RE: Commons at Dry Creek Planned Unit Development (PUD) PD-16-00001 and Preliminary Plat (LP-17-00004) – 30 Day Notice of Application Expiration

RE: Commons at Dry Creek Planned Unit Development (PUD) PD-16-00001 and Preliminary Plat (LP-17-00004) – Transmittal of Comments Letter from Re-Notice and Request for Additional Information

LOWELL/JACKSON PROP.

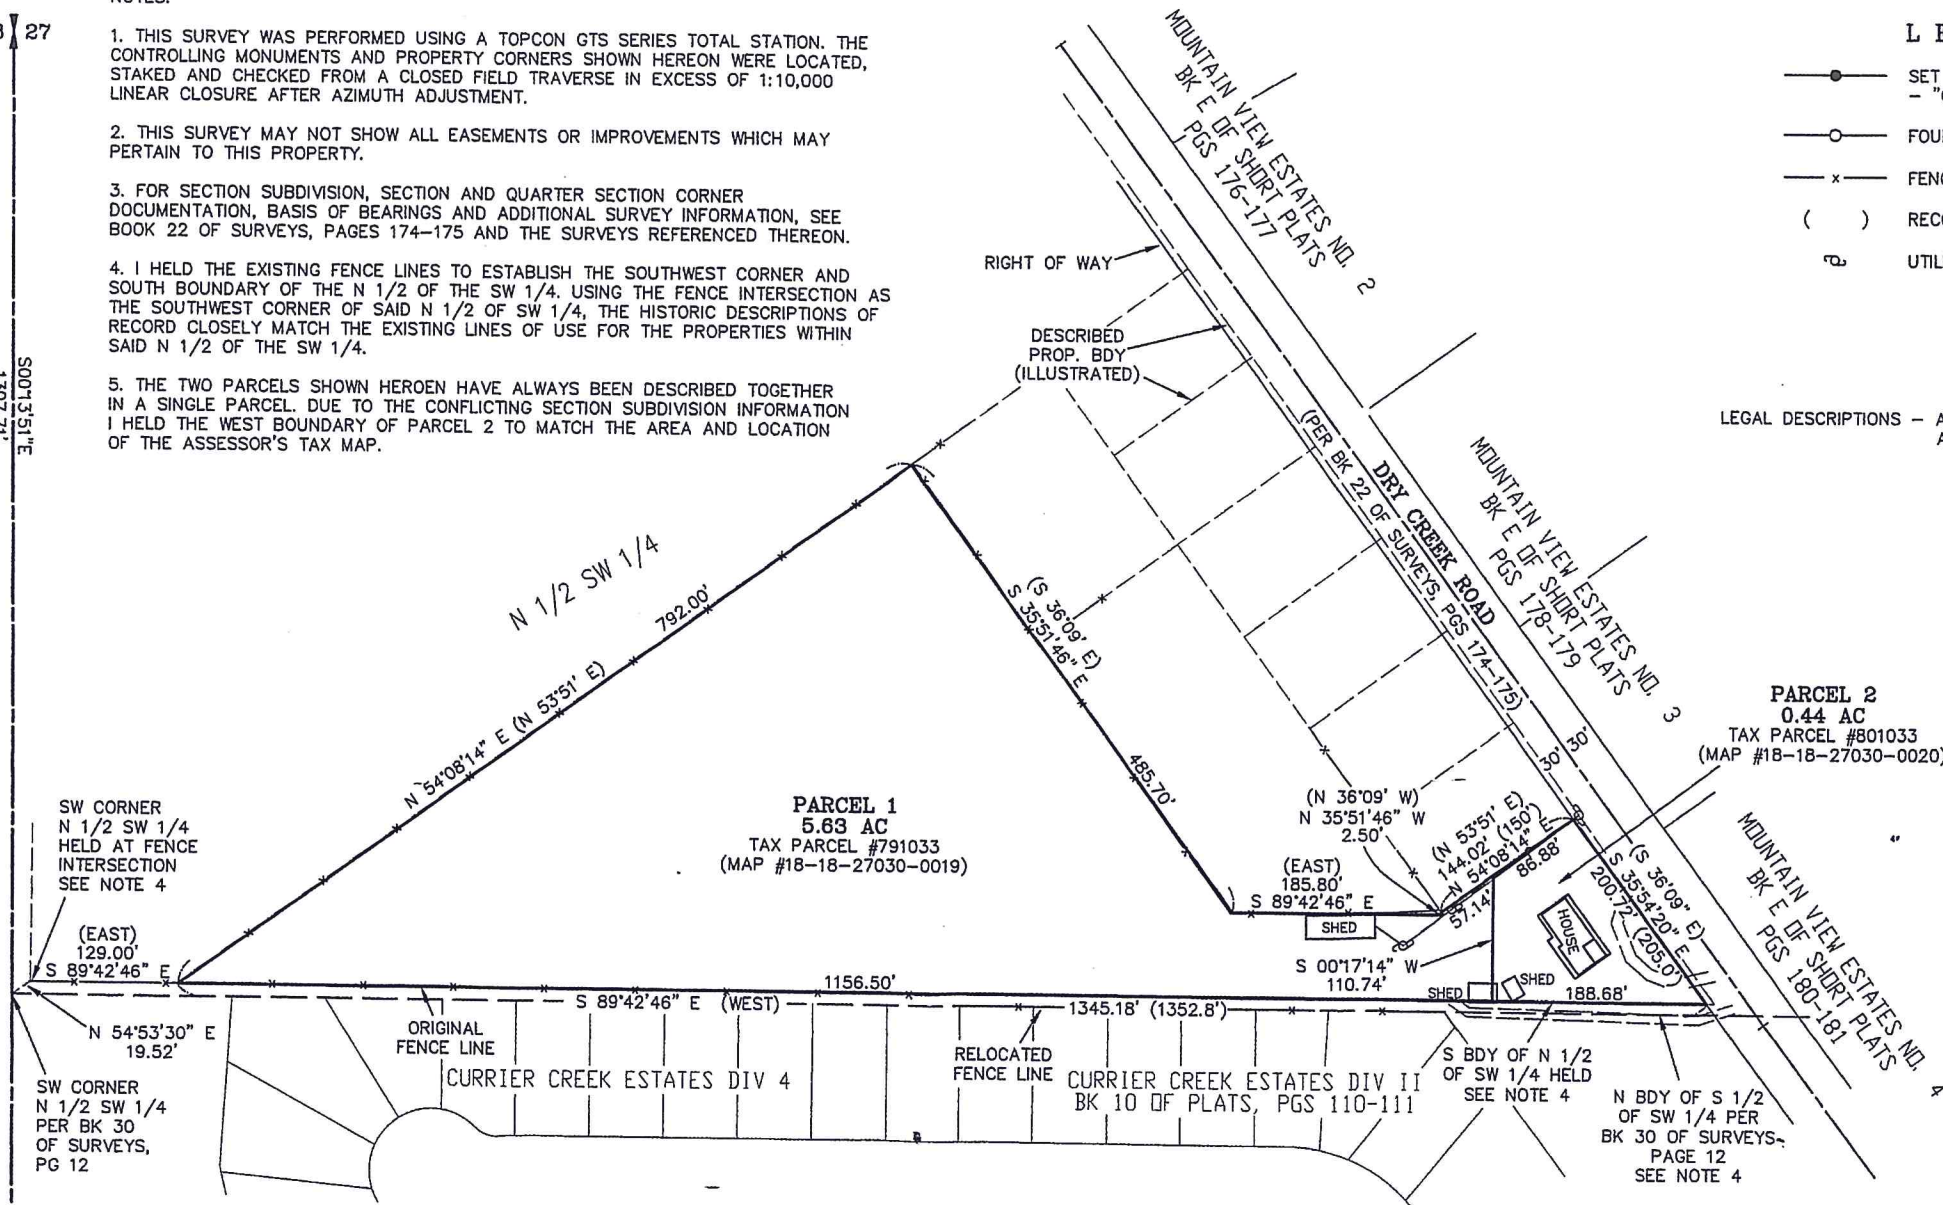
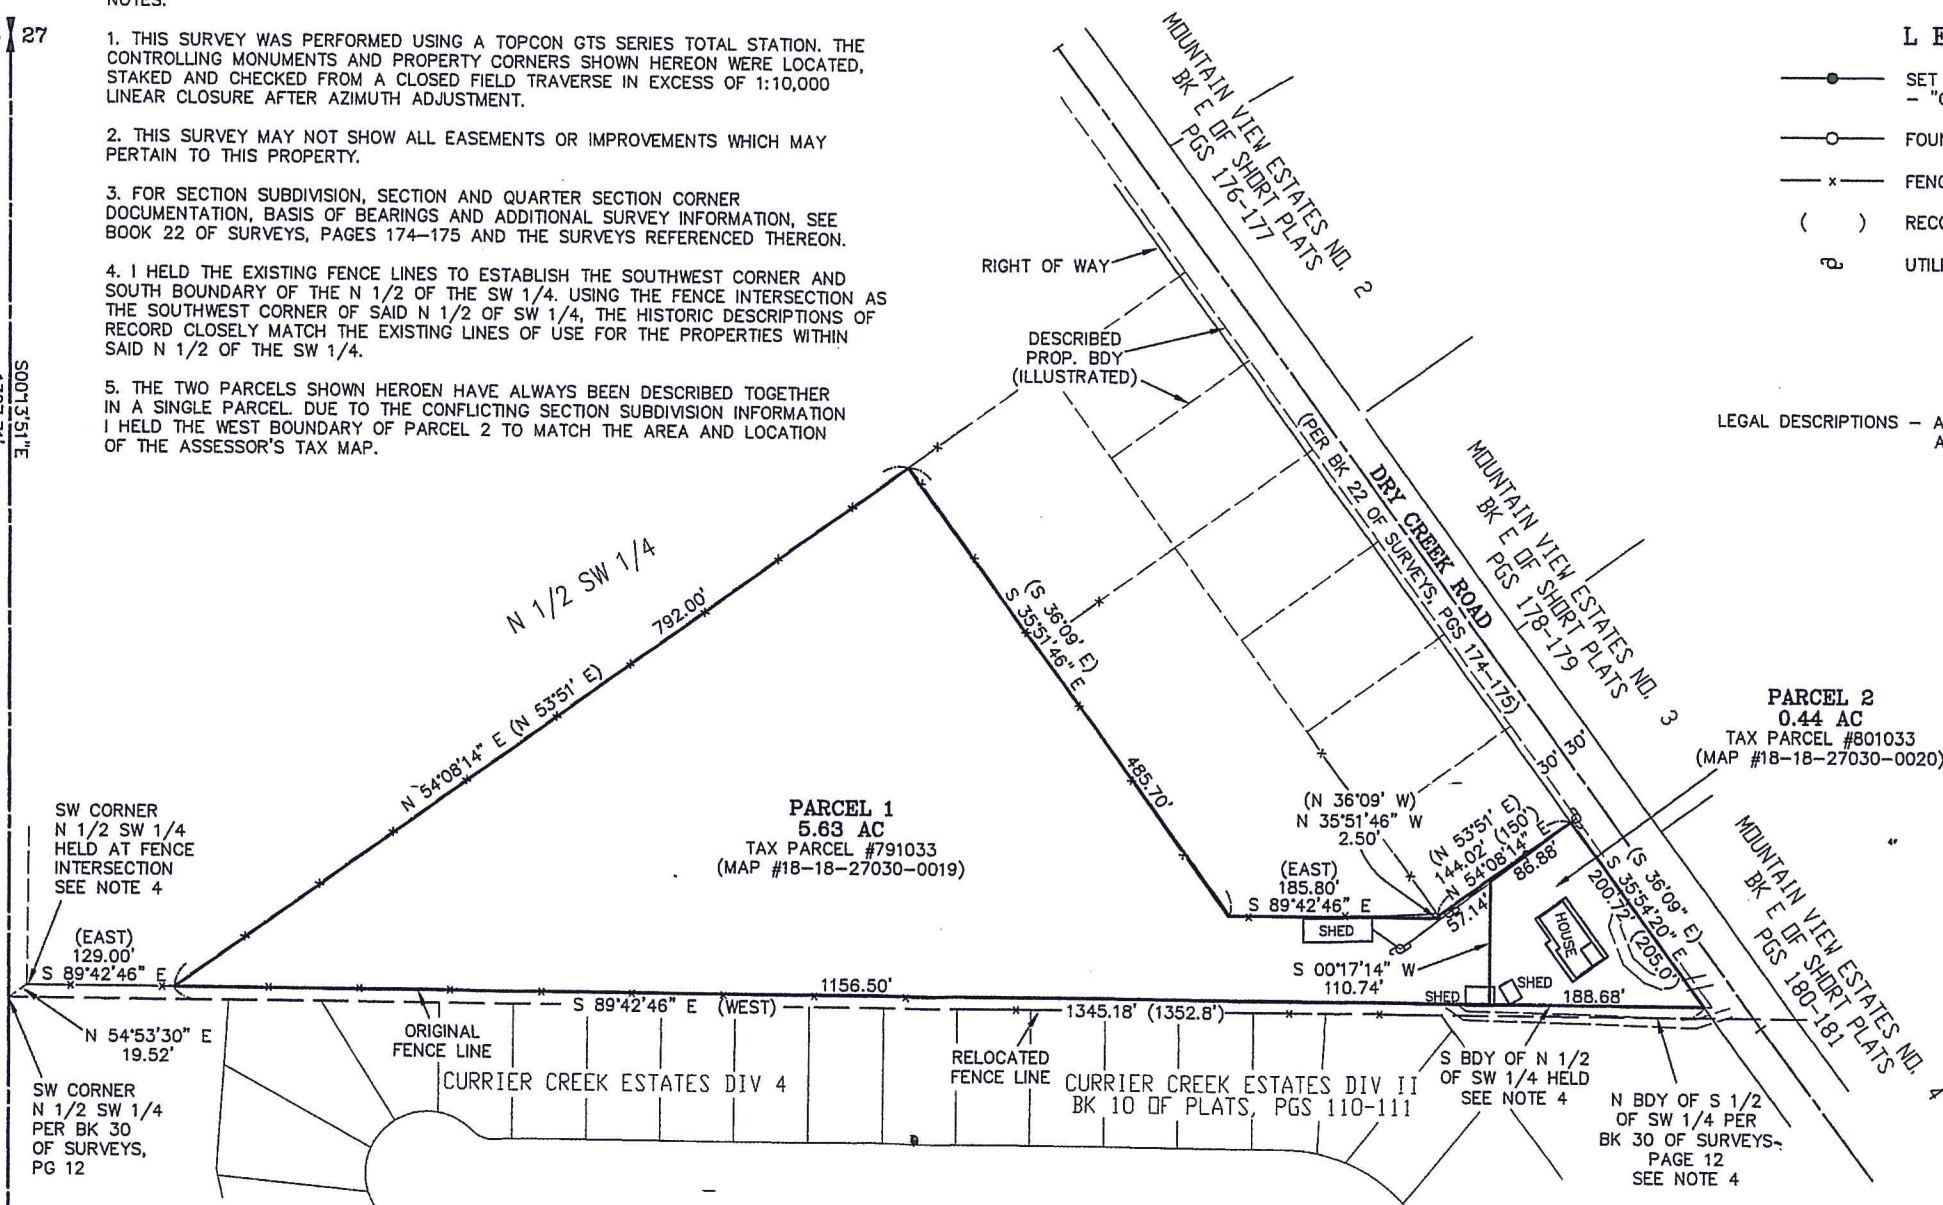
- f. The submitted preliminary survey was not signed by a licensed land surveyor, and the Surveyor’s certificate is not shown on the face of the plat.

- g. The legal description of the property to be subdivided must be included.
 - h. The vertical datum used is not noted, nor is the basis of bearings shown.

- i. A statement describing equipment and procedures used is not shown on the plat.
 - j. Buffer Setback Line is not shown in the Legend.
 - k. The access easement through the adjacent parcel must be shown on the face of the plat.

- 6) A revised preliminary survey meeting items 2(f - k) above.

- 2) An updated stormwater drainage report depicting soil characteristics in regards to stormwater infiltration, and demonstrating that the proposal fully complies with the *Stormwater Management Manual of Eastern Washington*.
- 3) Complete a transportation concurrency application with Kittitas County Public Works. This application shall be submitted directly to Kittitas County Public Works; application is attached to this letter.
- 4) Provide the document "Infiltration Letter for Cottage Grove Residential Development, Kittitas, Washington".
- 5) An updated access easement meeting minimum side yard setbacks of 15 feet under KCC 17.22.060.
- 6) A revised preliminary survey meeting items 2(f - k) above.

EASEMENT DESCRIPTION

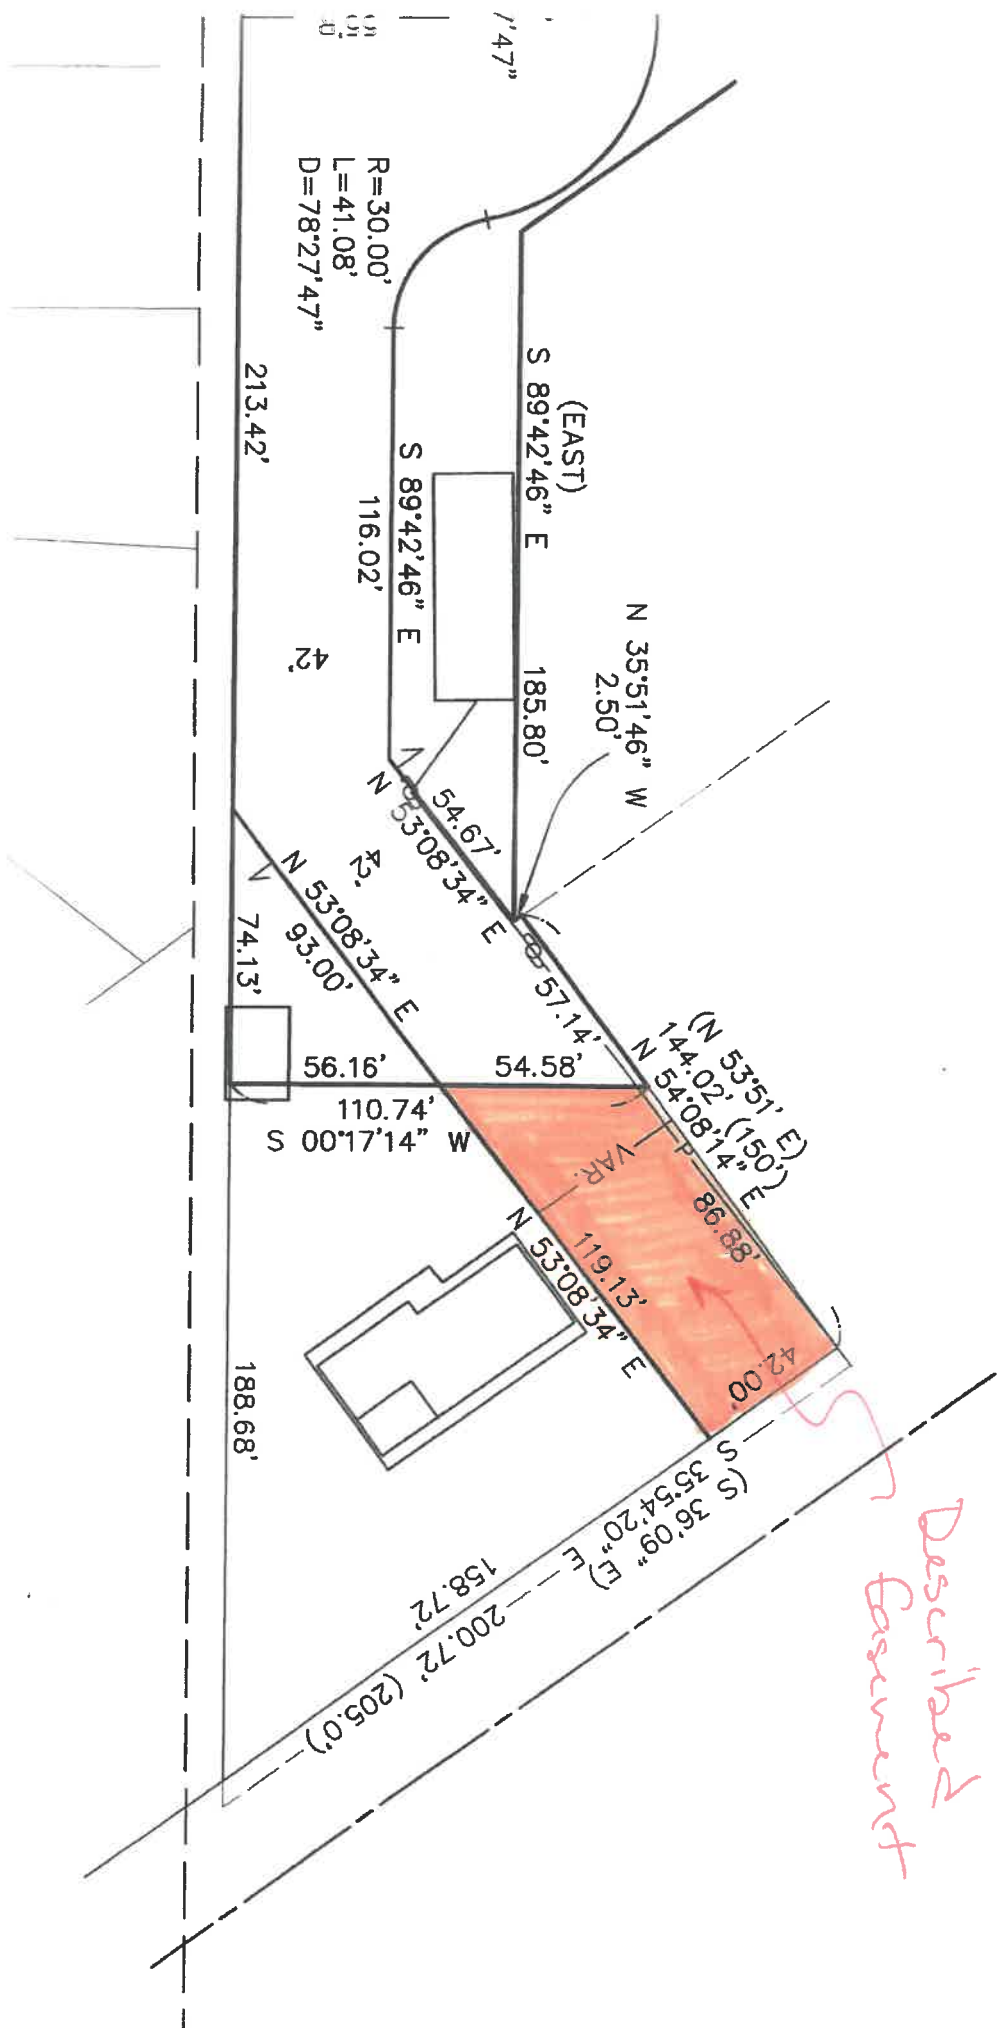
- d. Flooding has occurred proximate to the proposed development.
 - e. The current recorded access easement does not meet the required minimum side yard setback of 15 feet.

- 4) Provide the document "Infiltration Letter for Cottage Grove Residential Development, Kittitas, Washington".
- 5) An updated access easement meeting minimum side yard setbacks of 15 feet under KCC 17.22.060.
